Subject: FW: AW/237/19/PL The Former Ship Inn, Aldwick

I now have our Highways comments. Just one thing, can you comment on the point she raises in her email below about the bollards.

Client
One Stop Stores Limited
Project
The Former Ship Inn, Aldwick Street, Bognor Regis. PO21 3AP
Title
Site Location Plan with Vehicle Tracking : Articulated Vehicle
Scale
1:500 @ A1
Date
07.01.2020
Drawn By
PAL
Checked By
PM
Project No:
B190031
Drawing No:
B 202
Revision
A

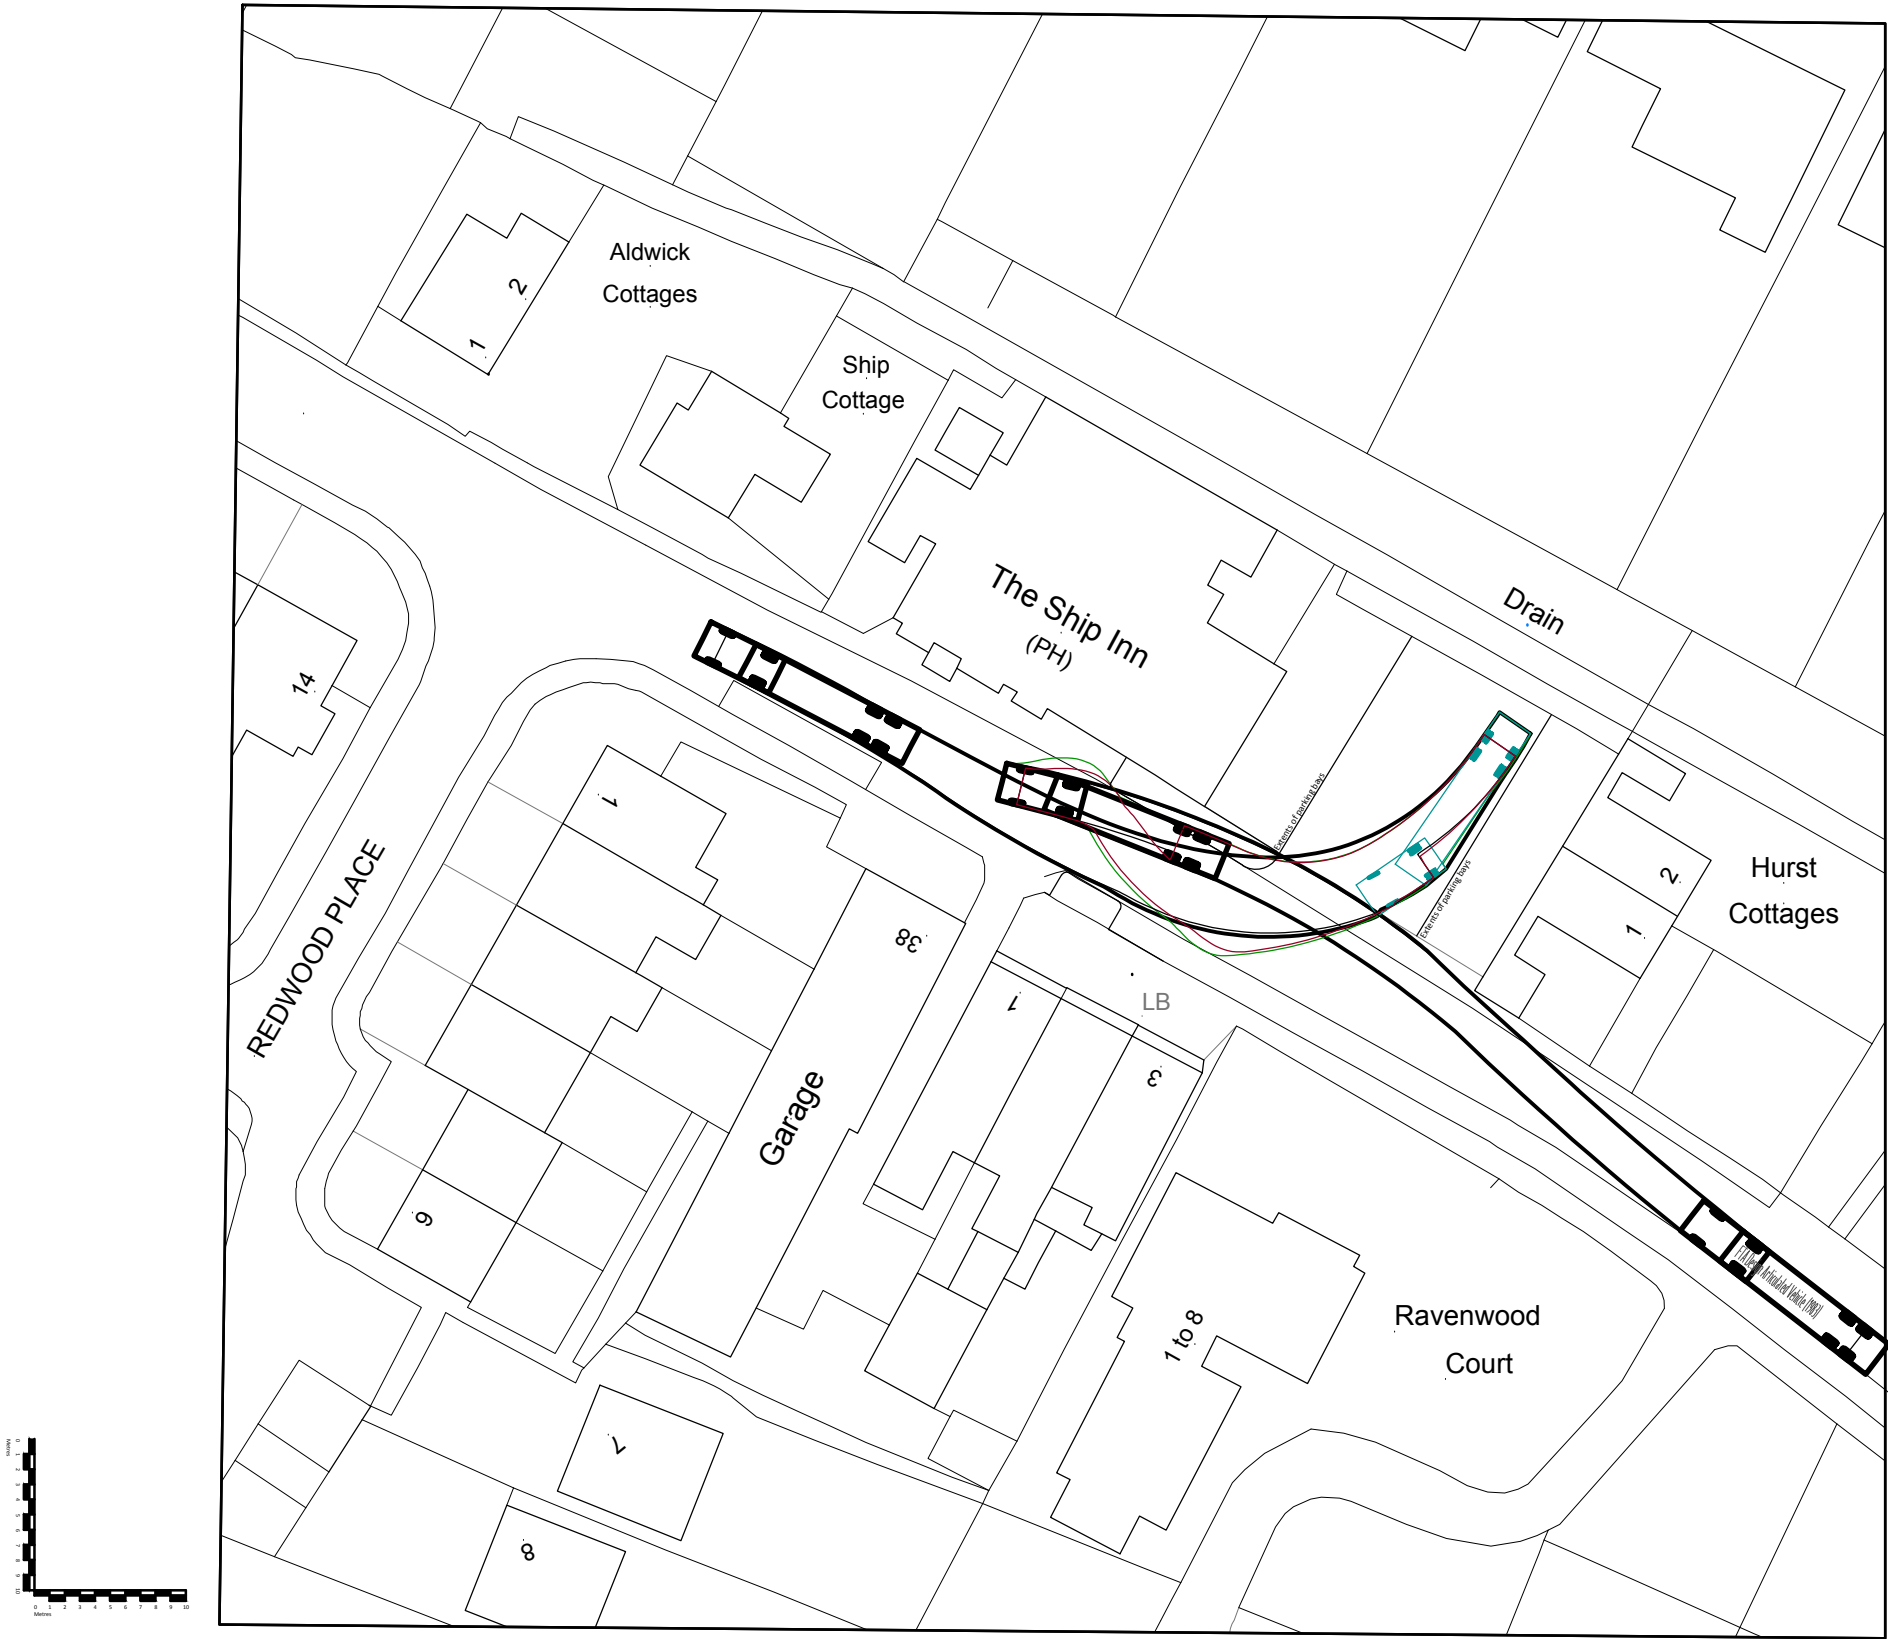
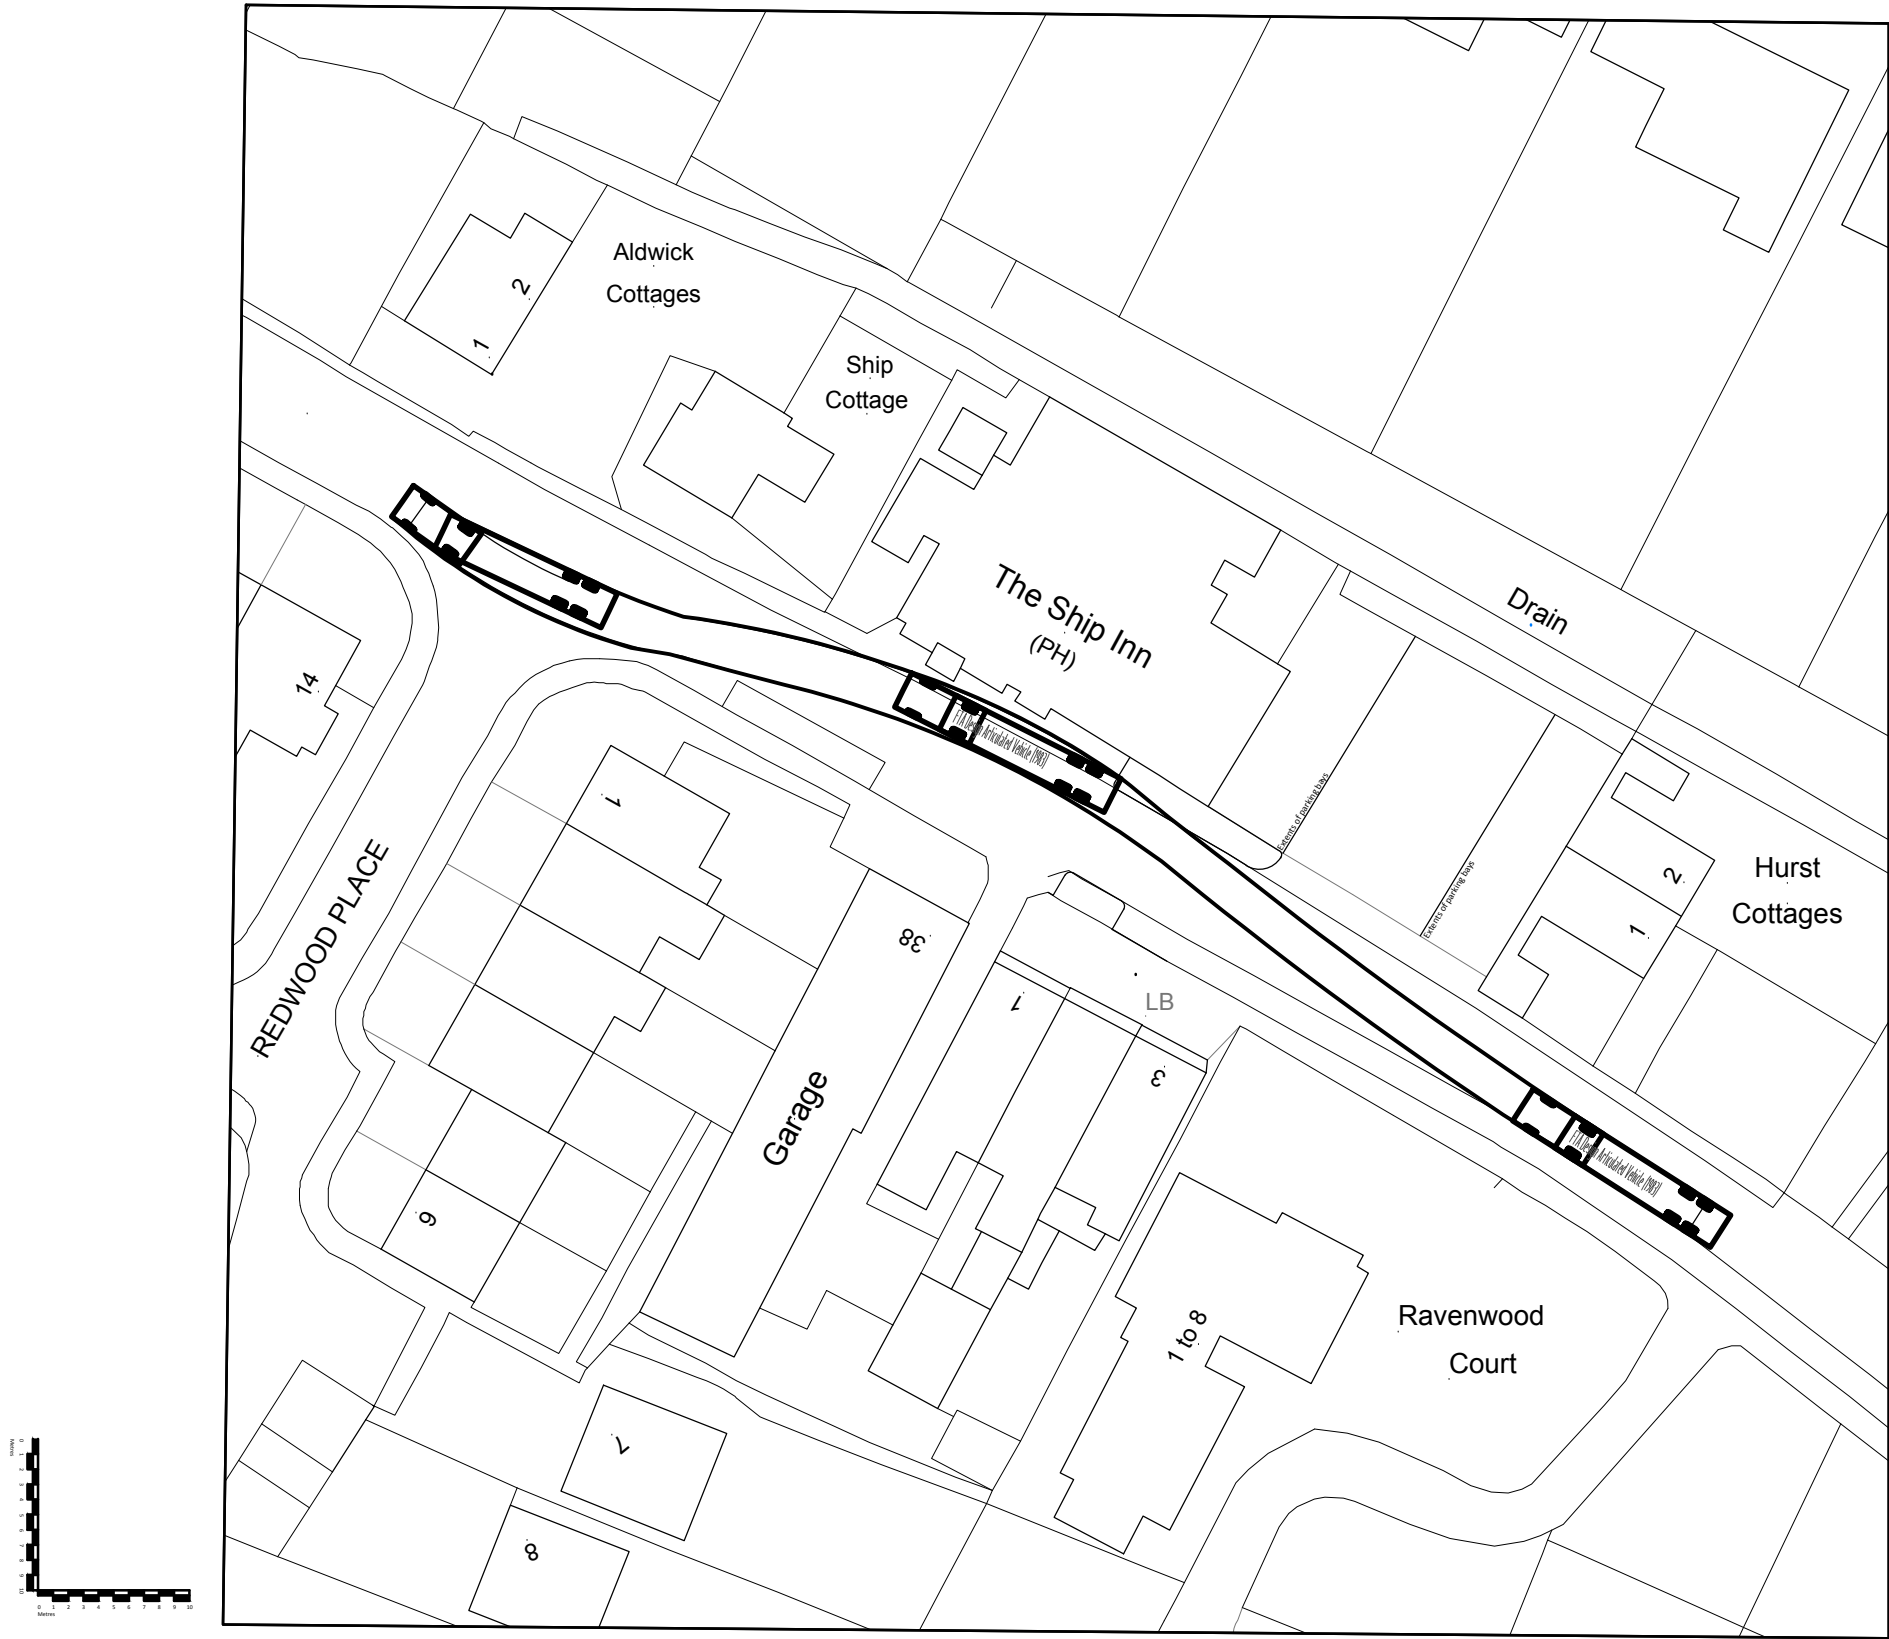
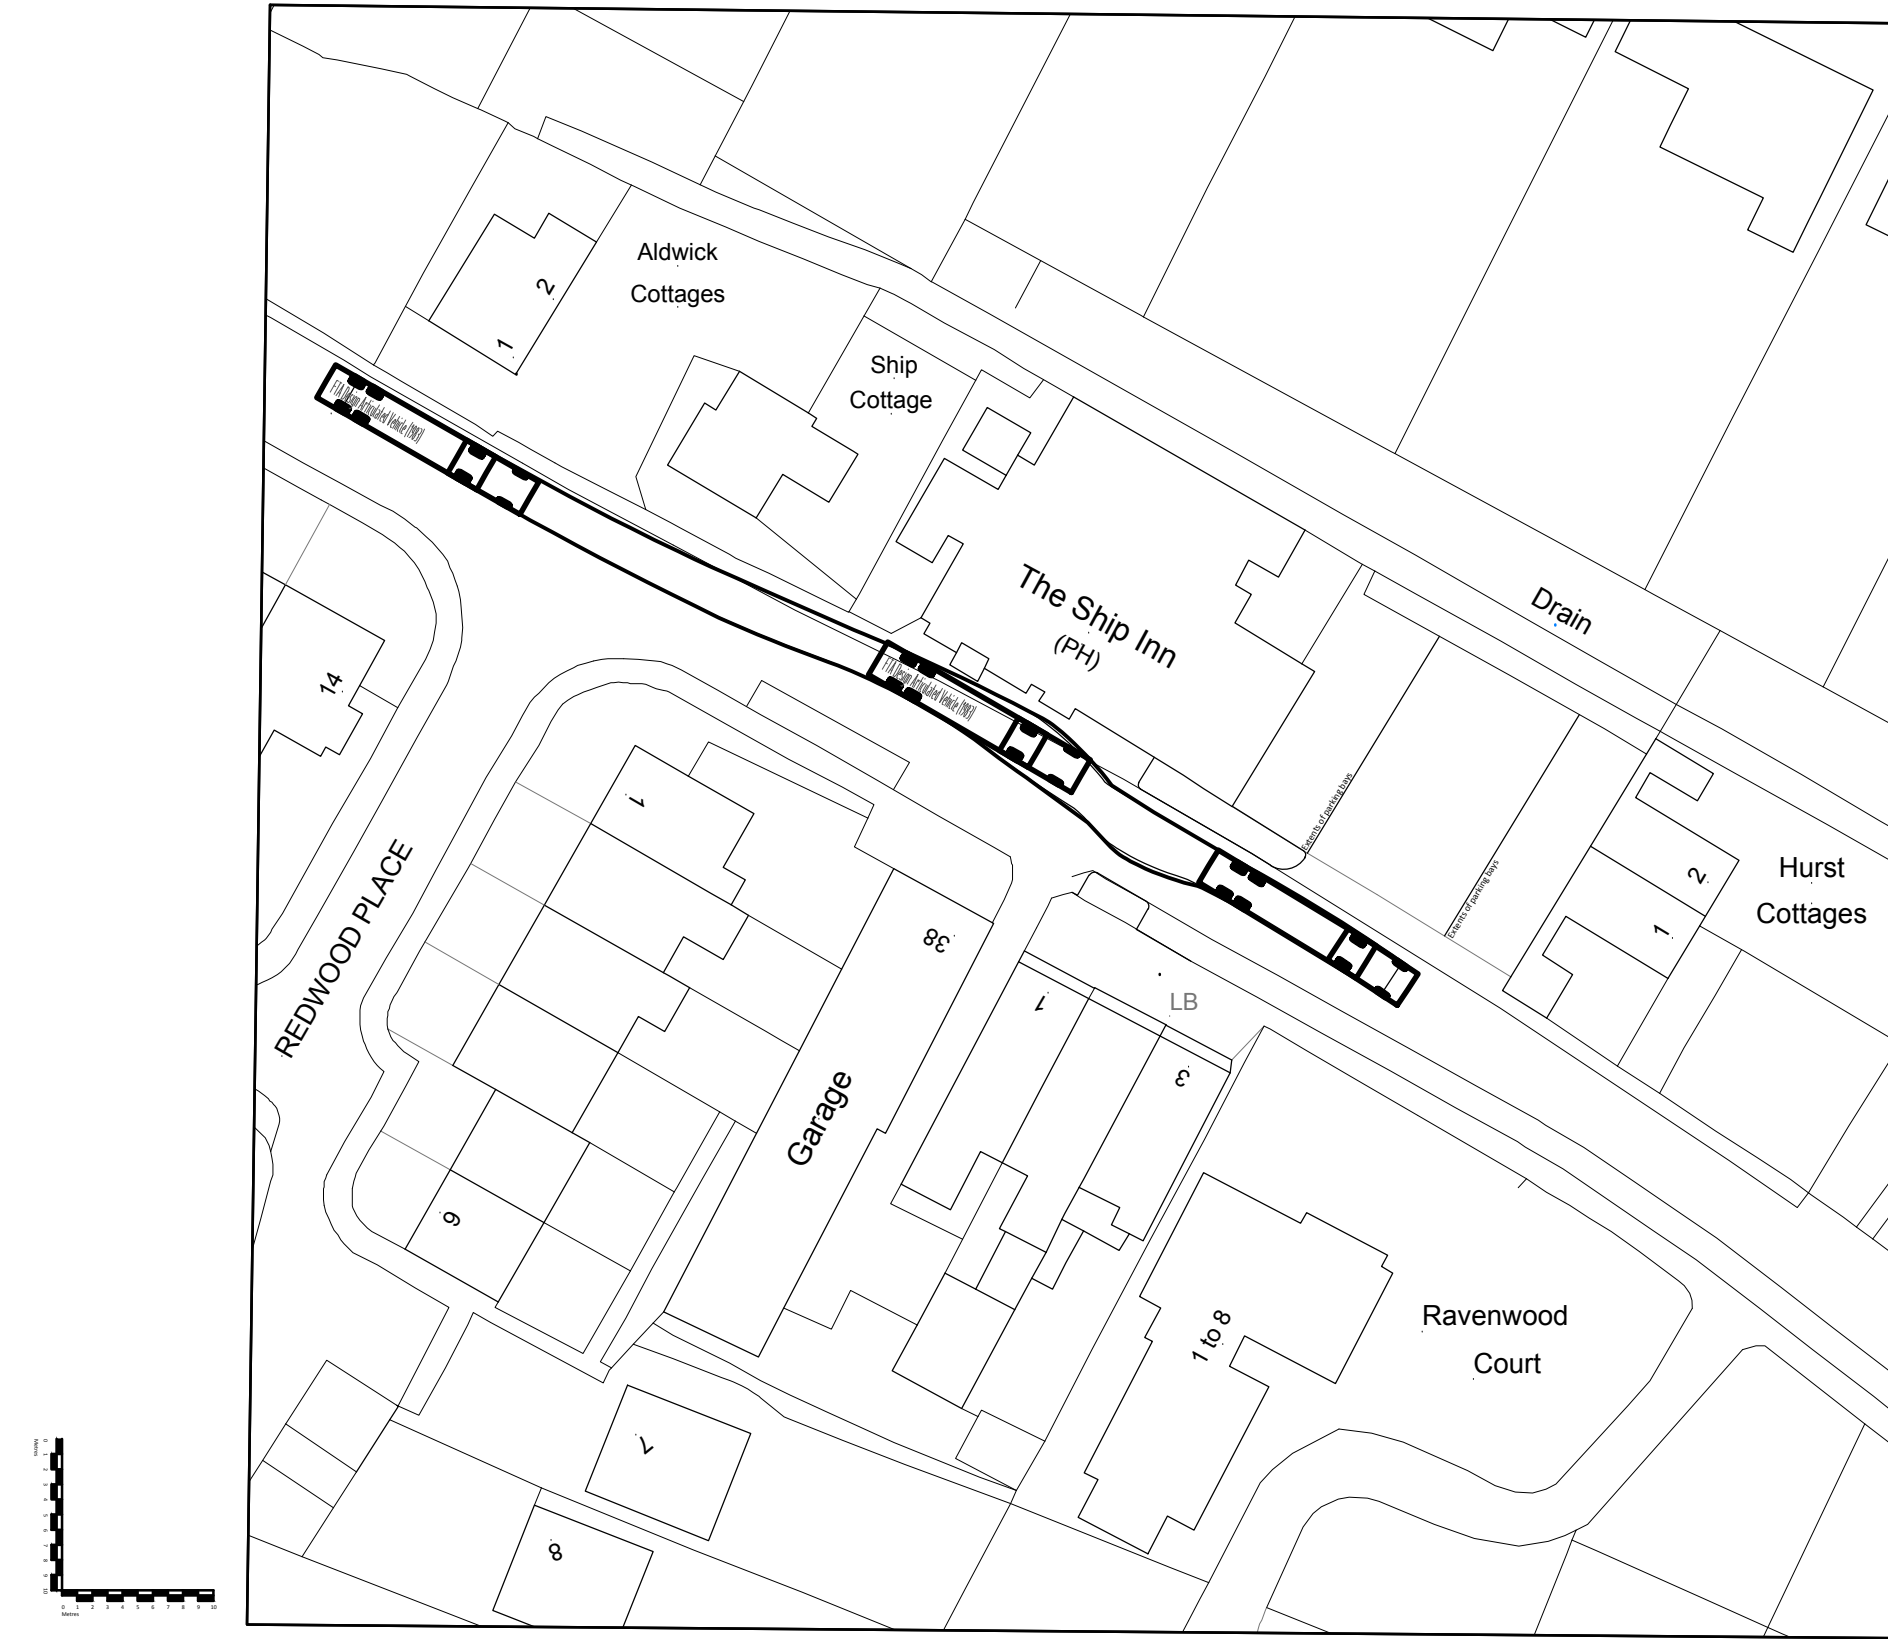
Many thanks for the documents which I have been able to review and provide some comments for you, attached. Whilst the RSA does not propose anything new to what has already been approved under the original planning approval, the updated tracking does show that an articulated lorry would not be able to use the car park for loading and unloading without over running the northern buildout. We have also noticed that any articulated movements should preferably travel to the site from the west and leave from the east to avoid over running the northern build out. This should be reflected in the delivery management schedule. Clarification should be sought over whether the existing bollards in the highway will remain, as it is not clear where these are in relation to the tracked vehicle.

The part about delivery vehicle movements can be covered by the delivery management schedule condition on the original permission so no need to update the schedule.
